Your Ref: OWPC21371
Our Ref: R/4/19/HH 09-01-2019
Please ask for:
Zac Denton

Front and rear single storey extensions and dormers to front and rear roof slopes.

32 Mill Lane Rustington

PROPOSED REAR ELEVATION
1:100

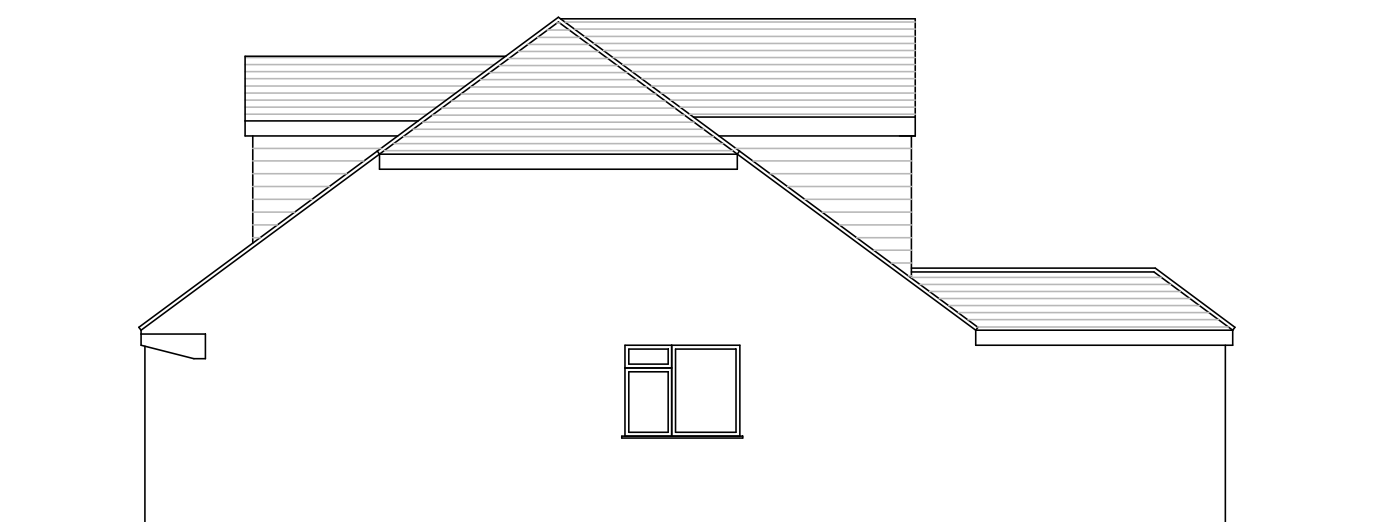
We wish to voice our objection to the above Planning Application. The proposed 'massive' and 'imposing' upper floor extension with large dormer windows to the rear of the property will overlook our bungalow and will face directly into our sitting room and kitchen. This will have a severe impact upon the privacy we have enjoyed for the past 37 years of living here. We will be unable to leave our curtains and blinds open as we currently do, or enjoy our garden without the feeling of being watched all the time. I hope the Planning Committee will take our views and concerns into consideration when determining this application. Norman and Pauline Young
